Whalley Parish Council

PLANNING APPLICATIONS

MB 3/2012/0618 Proposal: Single storey extension
Location: 13 Woodfield View Whalley BB7 9TB

OBJECTION

DRG NO:
PH 1

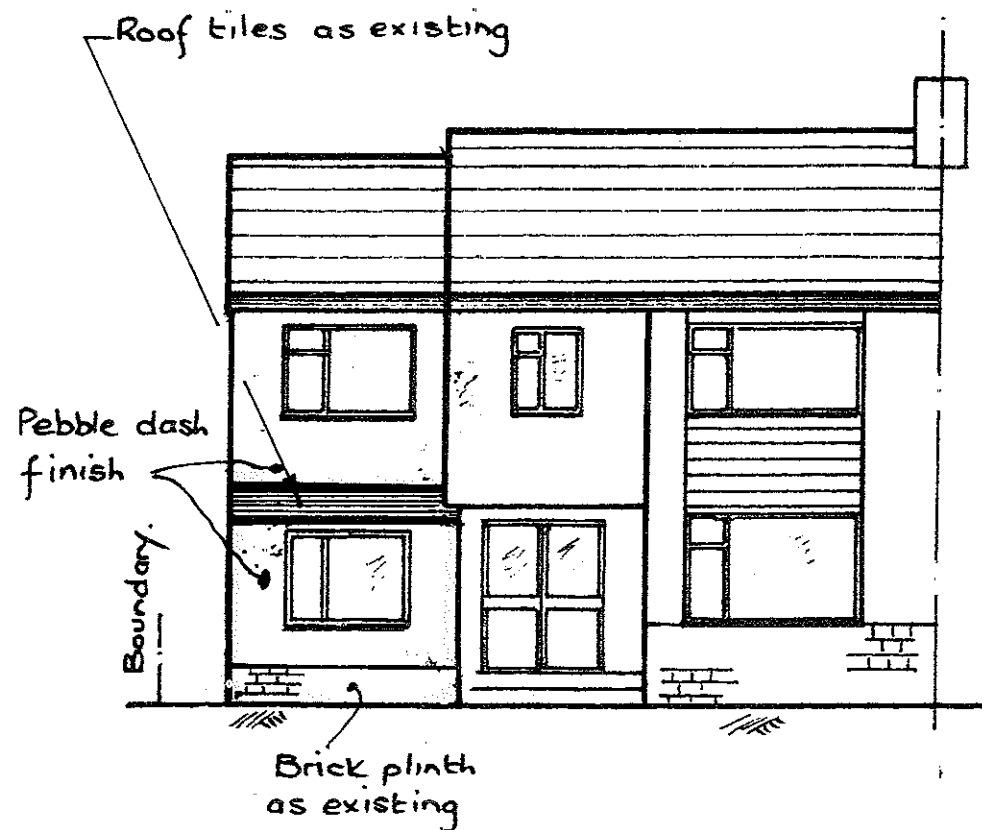
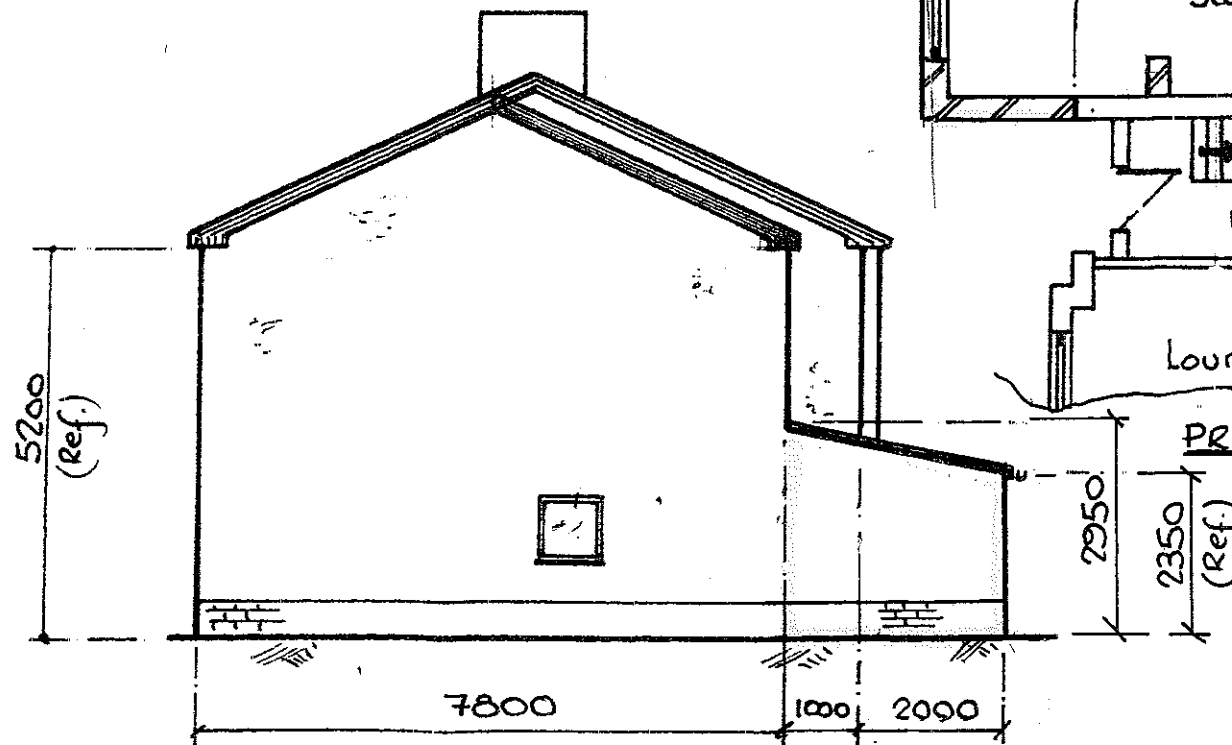
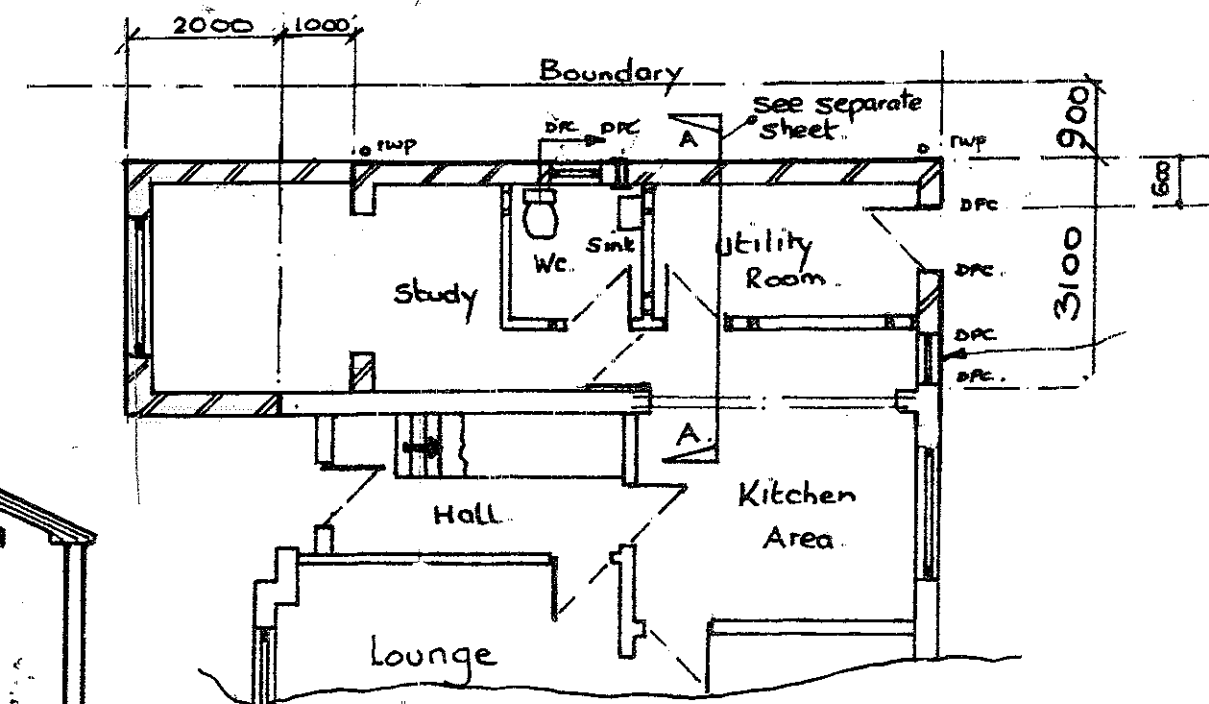
Clearly the proposed extension exceeds the building line by some 2 metres thereby intruding onto the adjacent property.
